27 March 2014

Our ref: DHB/08025

re: Application to Modify Approval to Southern Highlands Regional Shooting Complex (MP 06_0232 - Mod 4) – Preferred Project Report

Figure 4: Gunfire Noise Levels Measured at Residential Location A4

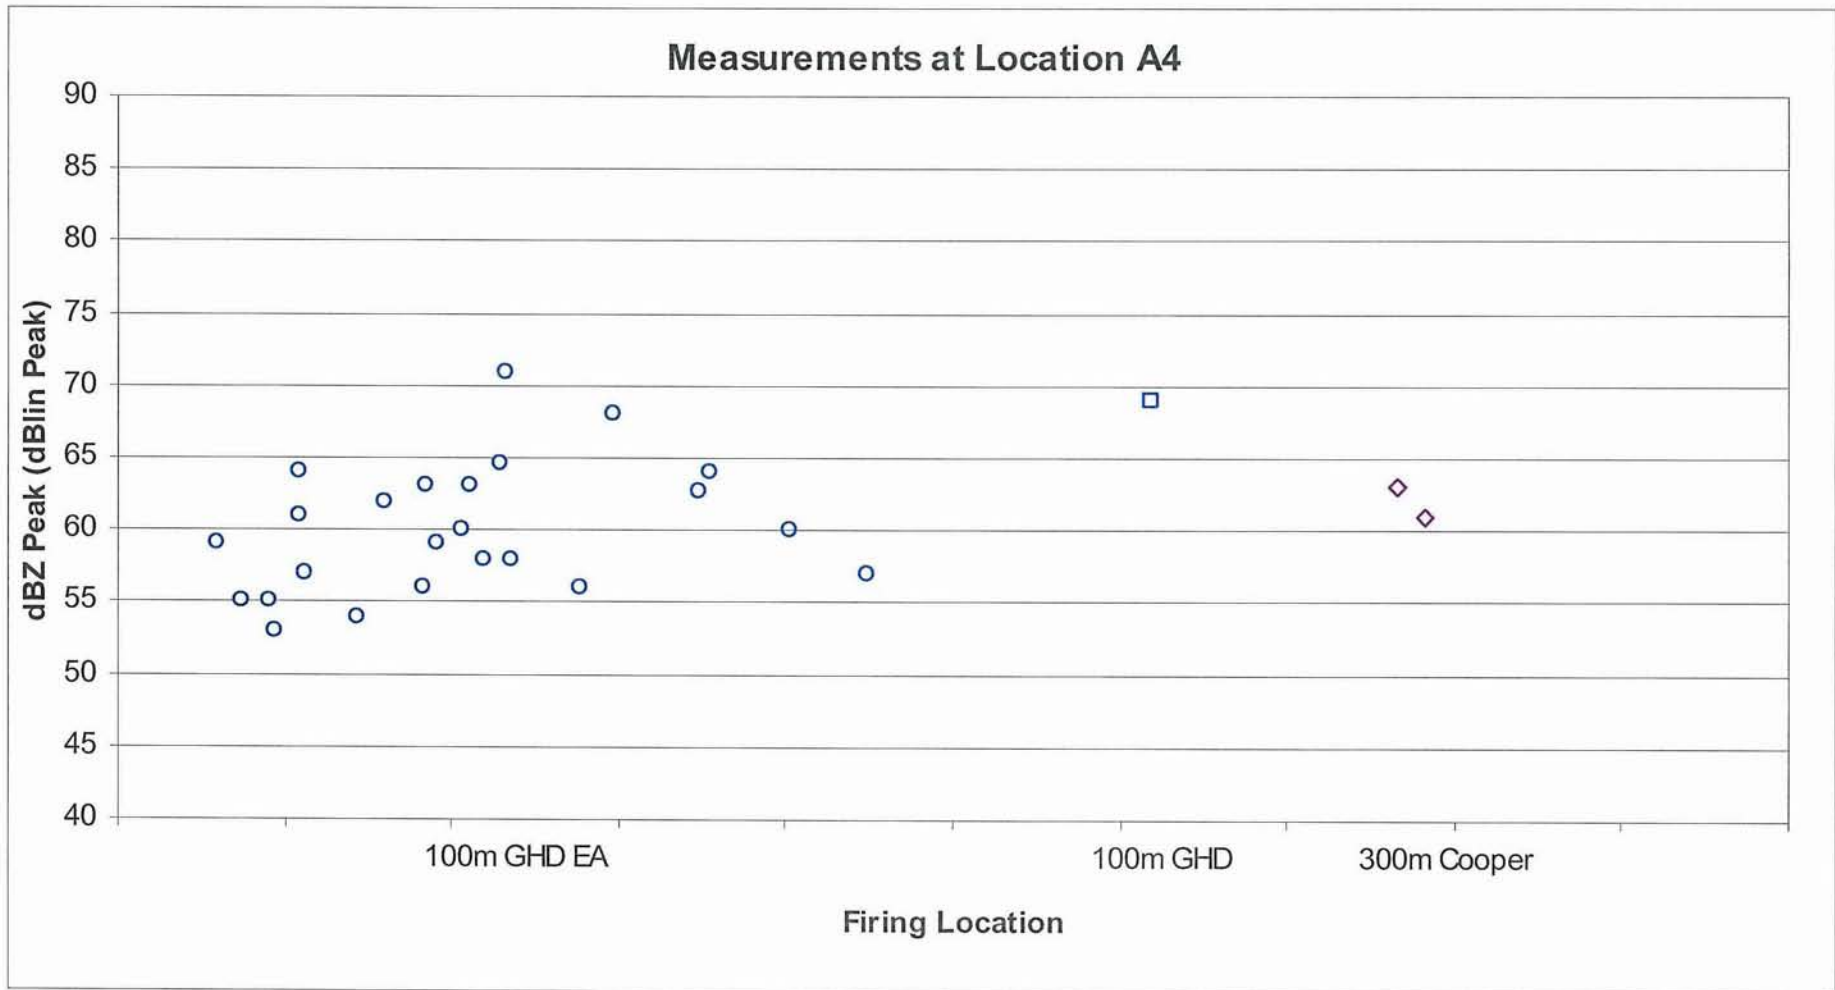
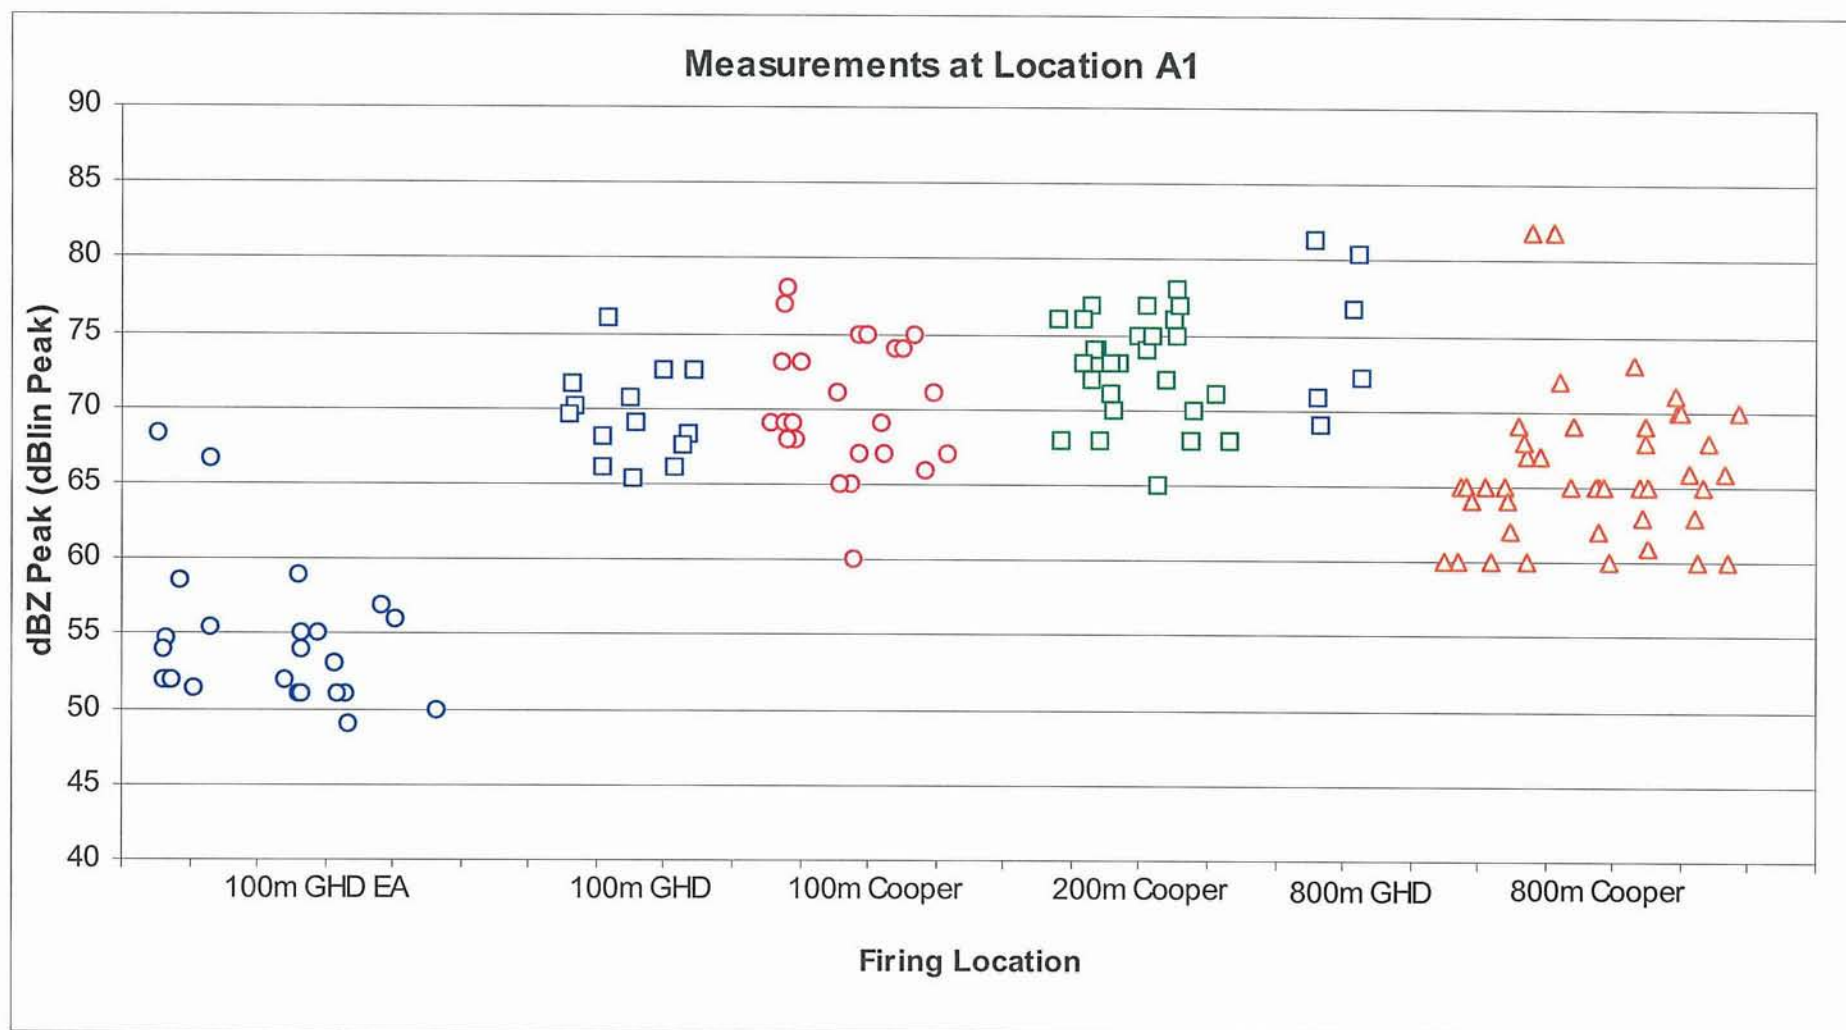
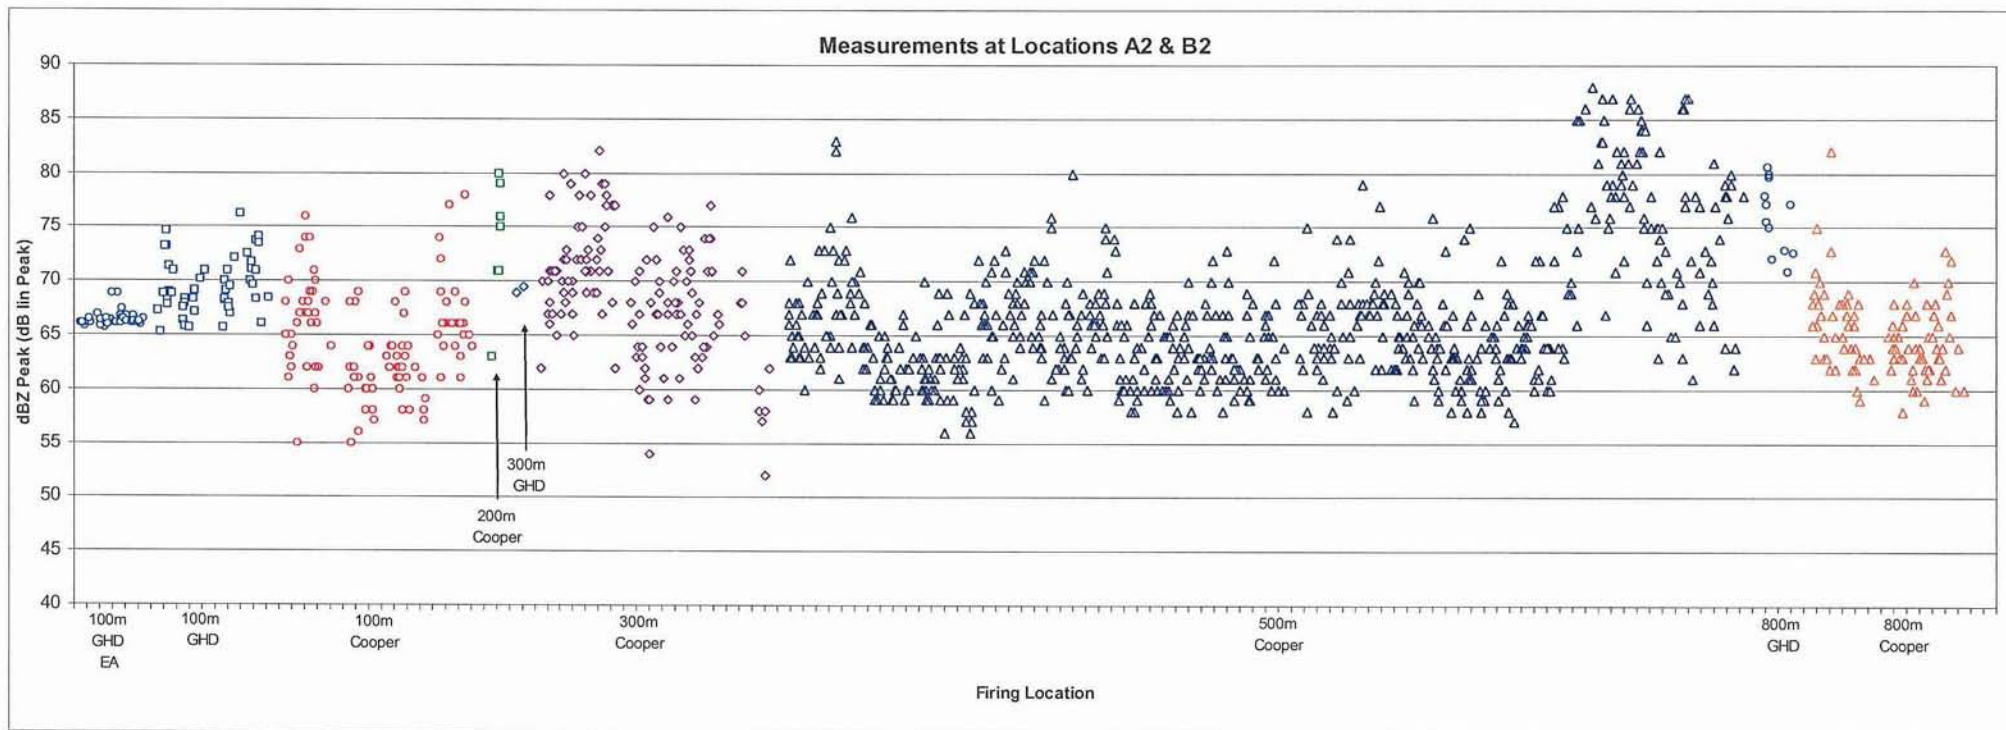
This is because the tests were invalid due to excessive wind.

As noted on page 15 (para 2) of the Cooper Report (letter from The Acoustic Group to Sport and Recreation dated 1 November 2013) refers to the EPA Industrial Noise Policy the presence of winds up to 5 m/s is satisfactory for ambient background noise measurements but that testing found wind of 5 m/s unsuitable for the measuring of rifle shooting in that the peak hold level measurements were controlled in many cases by the wind and not the shooting.

Wind on the day was consistently higher than 5m/s (18kph) - average wind speed on the day was 24-25kph with higher gusts

HTRAGI is of the view that the only tests which resulted in a set of 6 or more measurements that were 75dB or under are tests 17, 20, 23 at the 400m firing line. These tests are identical to tests that showed non-compliance at the same firing line for the same gun with the same acoustic wall (shipping containers). They cannot be relied upon to open the range. The 800m range is therefore being reopened based on severely wind affected non compliant limited shots data sets with only 3 test firings of 10 shots (28 shot measured at residences), out of 31 sets. **That is only 10% of the testing being compliant on this occasion).**

Consequently Sport and Recreation are requested to undertake additional testing of all the guns and screening tested on 27 September 2013 to gain sufficient acceptable information on which to base decisions on the effectiveness of certain screening techniques.
